**Our ref:** WA/2015/120640/02-L01

**Your ref:** TR010019

**Date:** 02 October 2015

**Summary Of Relevant Representations Previously Submitted 2 July 2015  
Development Consent Order Application M4 - Junctions 3-12 (Smart Motorway)**

PLAN SHOWING PROPOSED CULVERT WIDENING  
SCALE 1:100

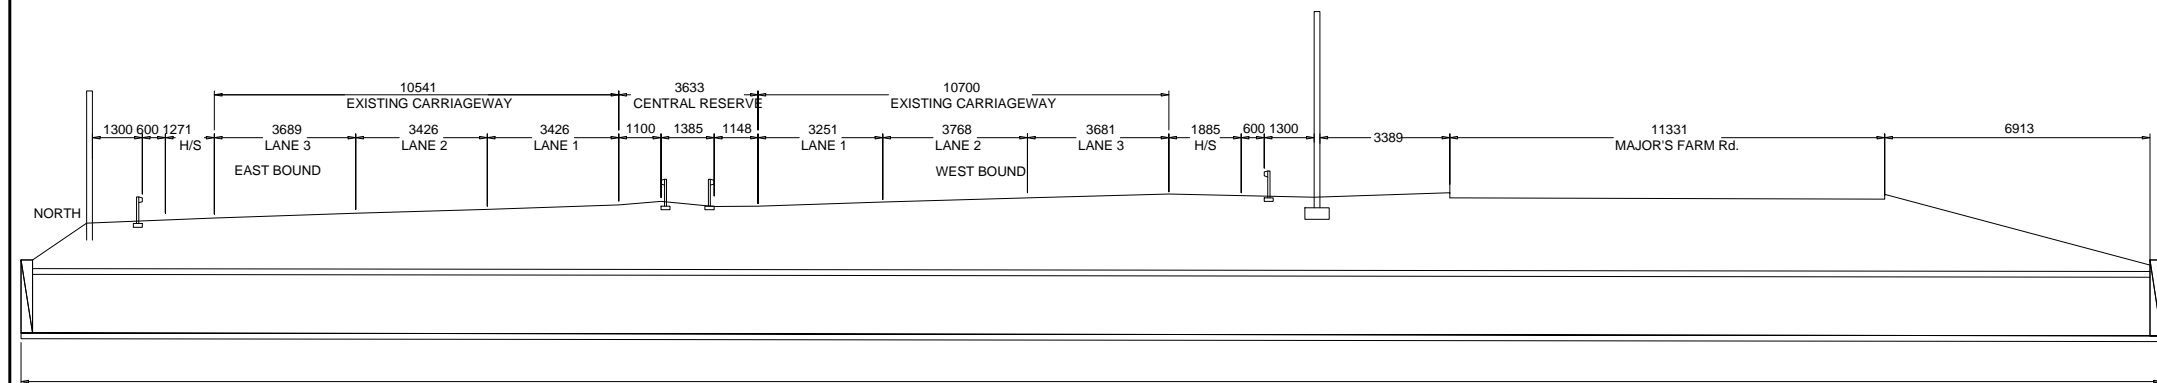
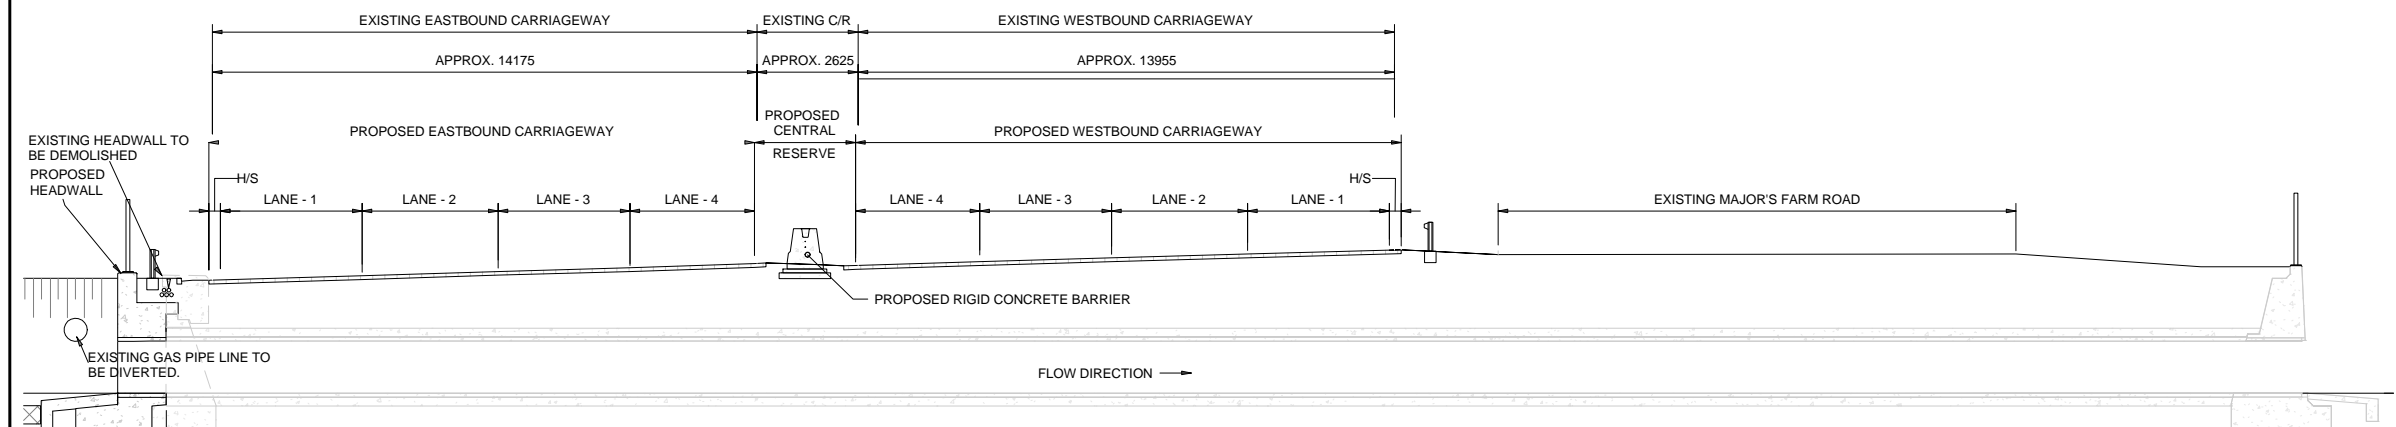
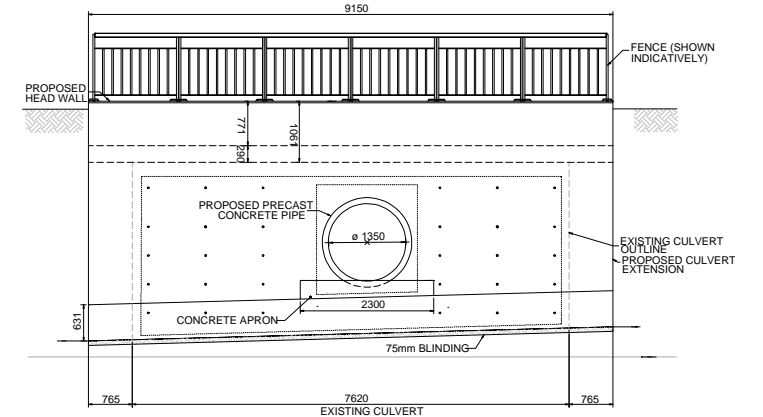
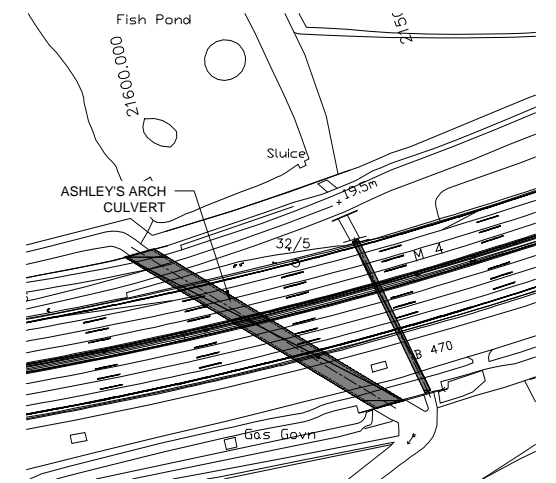
**Works to Culverts** - The applicant is proposing to undertake work to existing culverts but has not specified the extent of works required. It is noted that they will extending

them but the supplied information does not explain the lengths or design criteria. If extensions to culverts are not designed appropriately then flood risk could be increased.

Additionally, if extensions to culverts are not designed appropriately, they can impact on biodiversity by reducing connectivity of habitats and the ability of aquatic species and water dependent species to migrate. Works to culverts provide an opportunity to improve connectivity where it is currently a barrier to migration. This is supported by paragraphs 5.25 and 5.33 of the NPSNN.
